**From:** Contact Centre (CRM) <contact@ribblevalley.gov.uk>  
**Sent:** 24 July 2025 20:50  
**To:** Planning  
**Subject:** Planning Application Comments - 3/2025/0540 FS-Case-734031938

**Planning Application Reference No.:** 3/2025/0540

**Address of Development:** Brooklands  
Longworth rd  
Billington  
BB79TS

sheet name:
Proposed Second Floor and Roof Plan

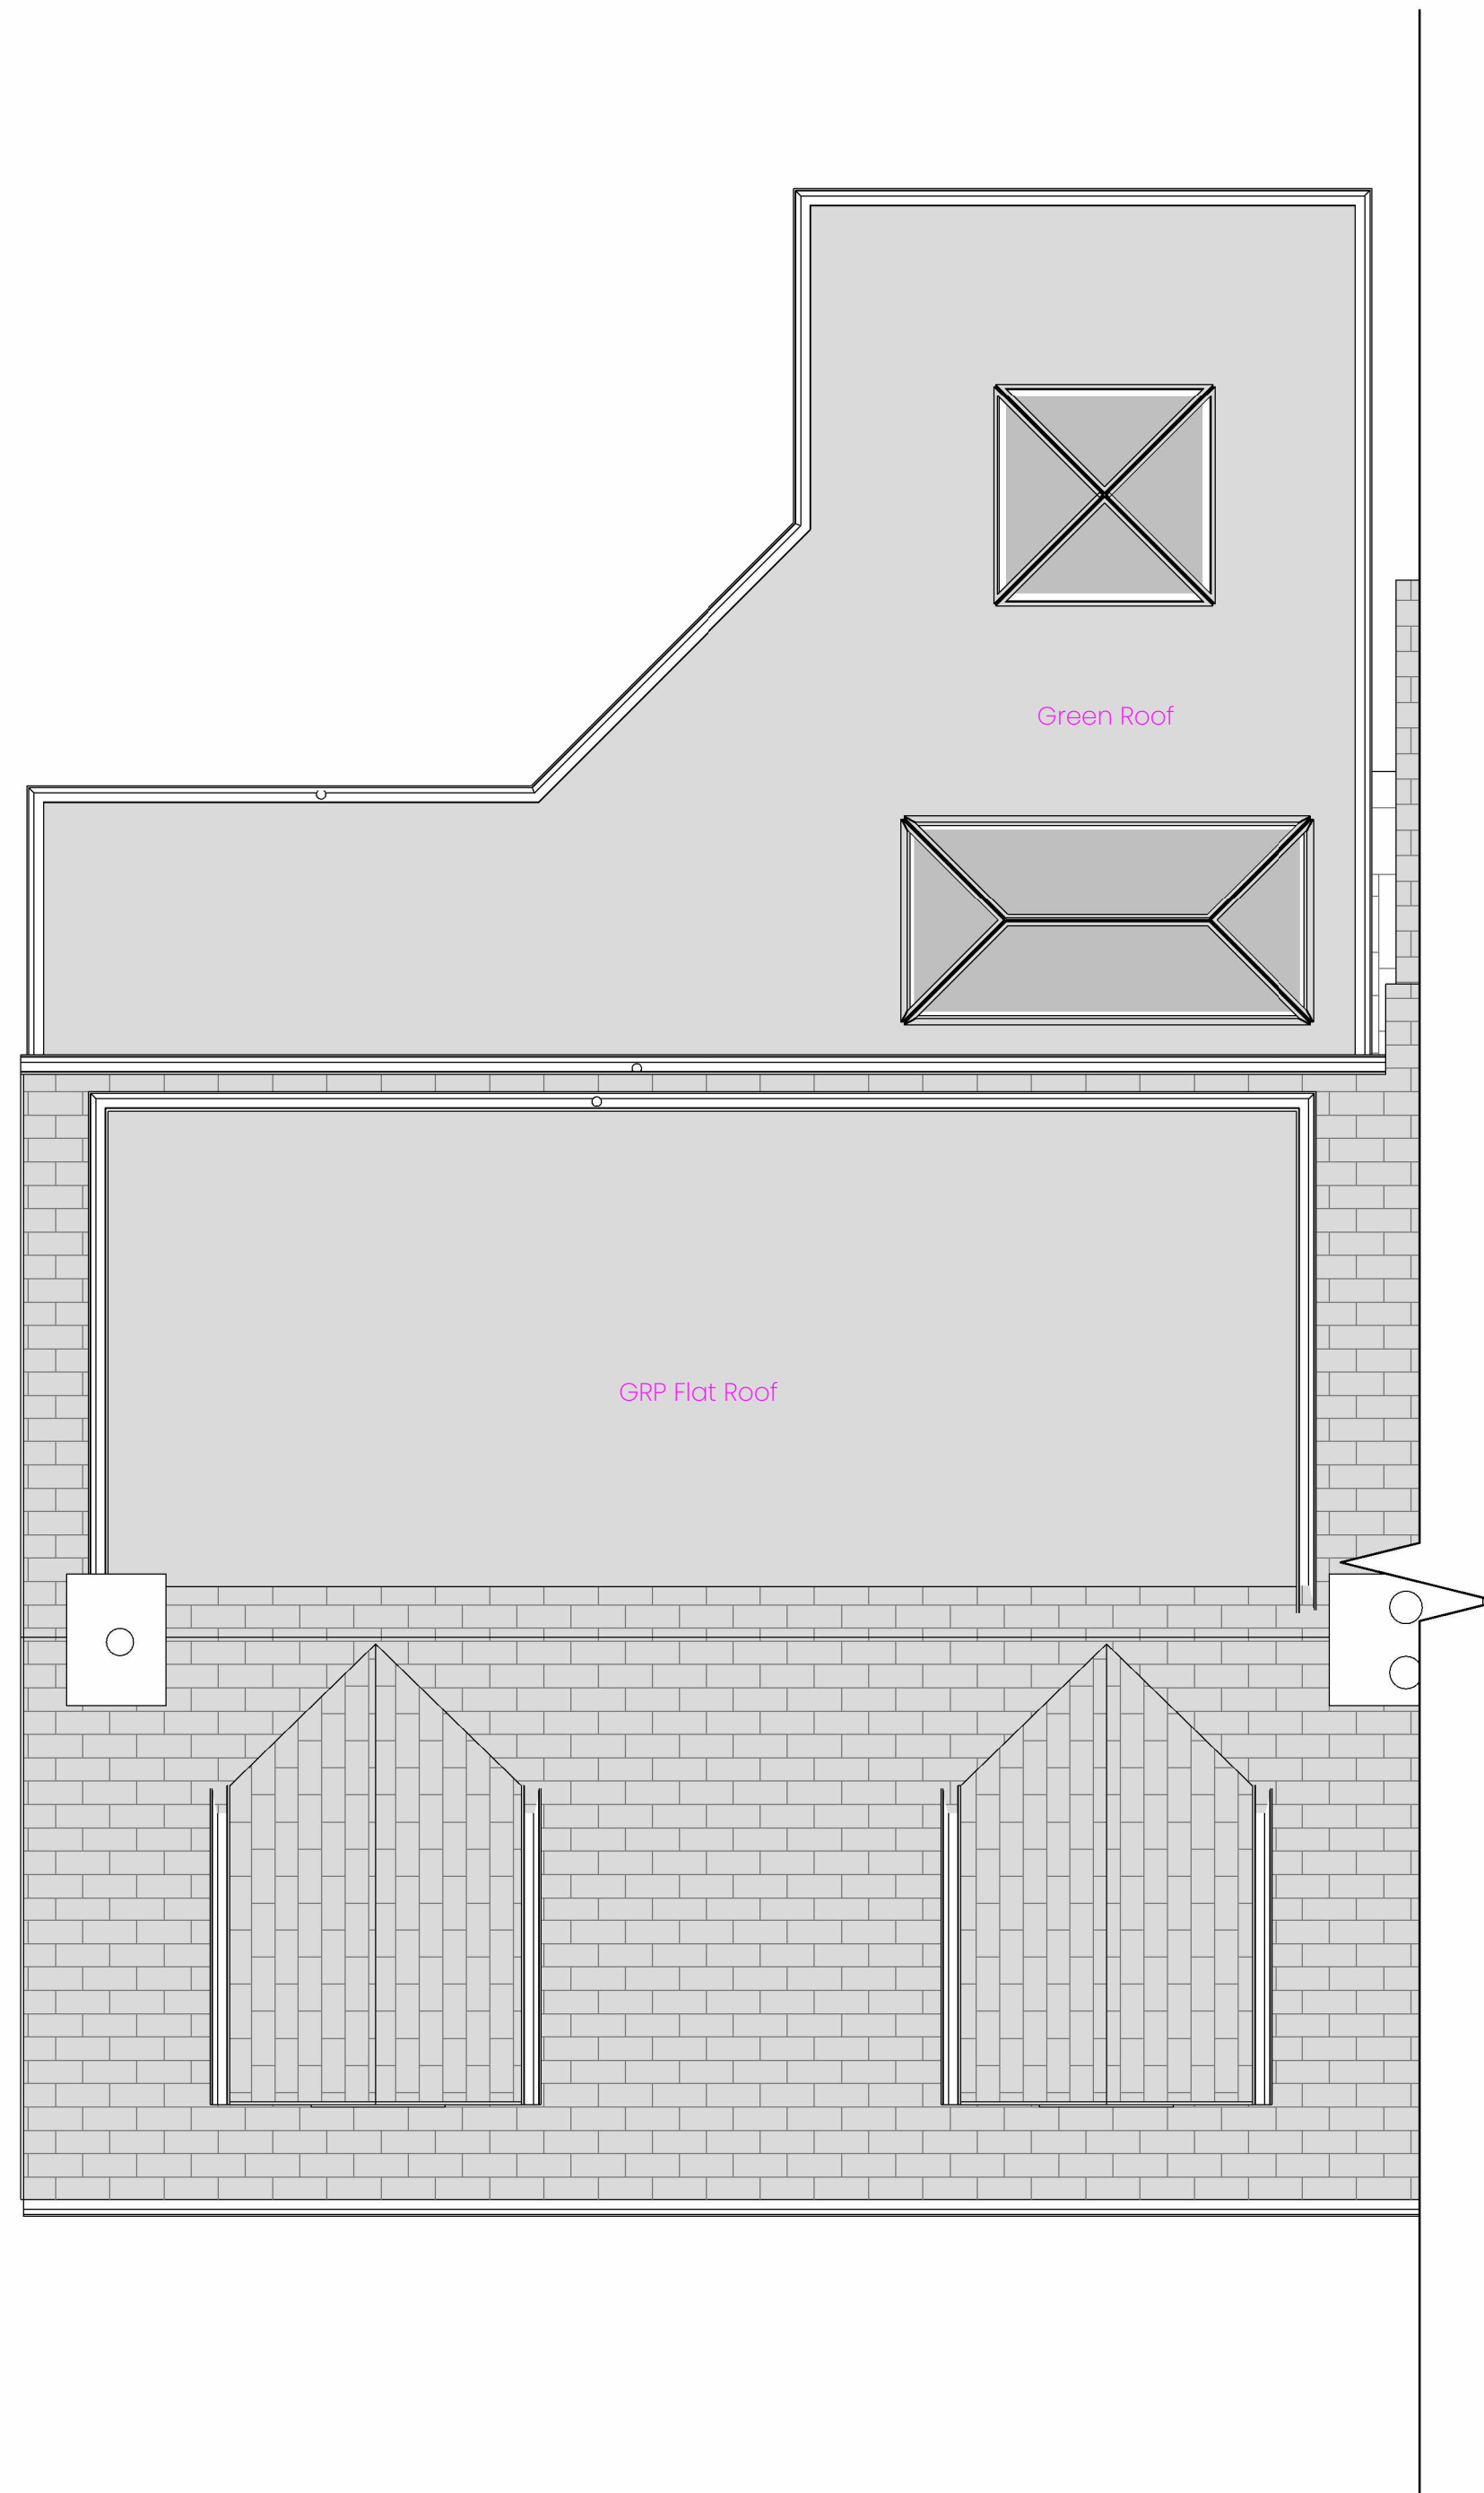
I very strongly oppose the dormer windows on the S/W aspect of this planning application.

Due to the geography of the location (slope) the dormer windows will [REDACTED]

[REDACTED].  
We have [REDACTED] and we are very concerned they can be very easily seen. Also from inside our house from many angles through our windows which is even more concerning.

These dormer windows would hugely infringe on our privacy, I hope you can see that too. In fact the only thing the dormer windows would achieve [REDACTED]
